STAFF REPORT

Jentges Conditional Use Permit (CU-26-00001)

TO: Kittitas County Hearing Examiner
FROM: Zach Torrance-Smith, Planner I
RE: Jentges Conditional Use Permit (CU-26-00001)
DATE: June 18, 2026 (Hearing Date)

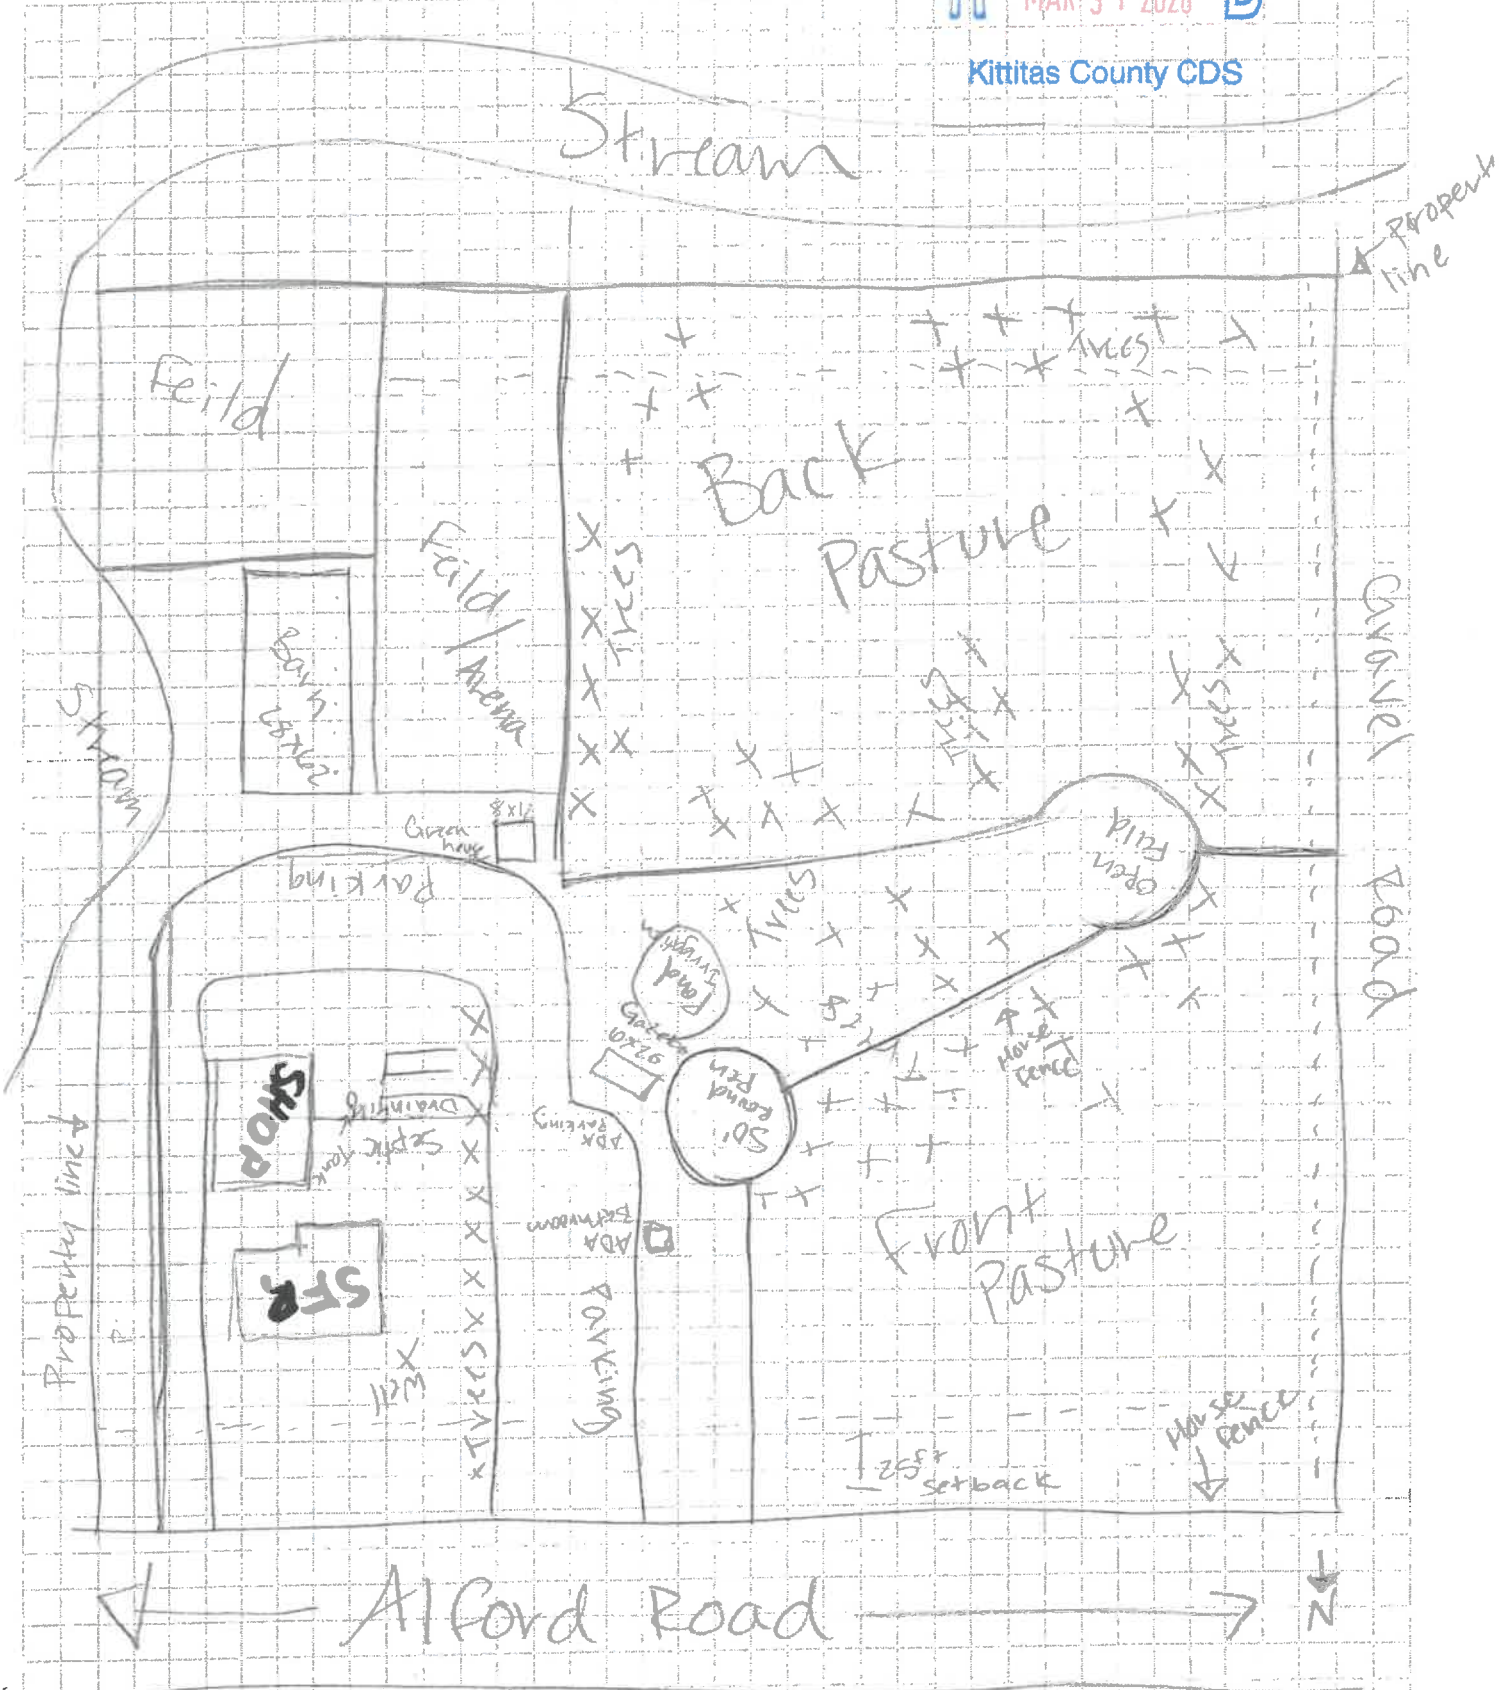
13. Accessible parking and route to Accessible space(s) provided with hard surface such as asphalt or concrete shall be required. The parking symbol and signage of Accessibility is required. Accessible parking spaces shall be located on the shortest accessible route of travel from adjacent parking to an accessible building/pedestrian entrance per WAC 51-50-1106. Wherever practical, the accessible route shall not cross lanes of vehicular traffic. Where crossing traffic lanes as necessary, the route shall be designated and marked as a crosswalk.

Verify there is no more than 1:20 slope for the Accessible path from Accessible Parking to the building(s) and all facilities entrances and amenities. Please show path and state the maximum allowed slope on the drawings.

All buildings or facilities shall be made Accessible per ANSI A-117; the latest adopted edition. Please show all Accessible features for rooms, counter areas and seating areas where Accessibility is required. Please show precise details such as counter heights, maximum reach distances, door swings, etc. Restrooms shall meet Accessibility with the same level of detail.

Please show this accessibility on an updated site plan and building permits for approval. Accessibility requirements must be approved by Kittitas County Community Development Services prior to any events taking place.
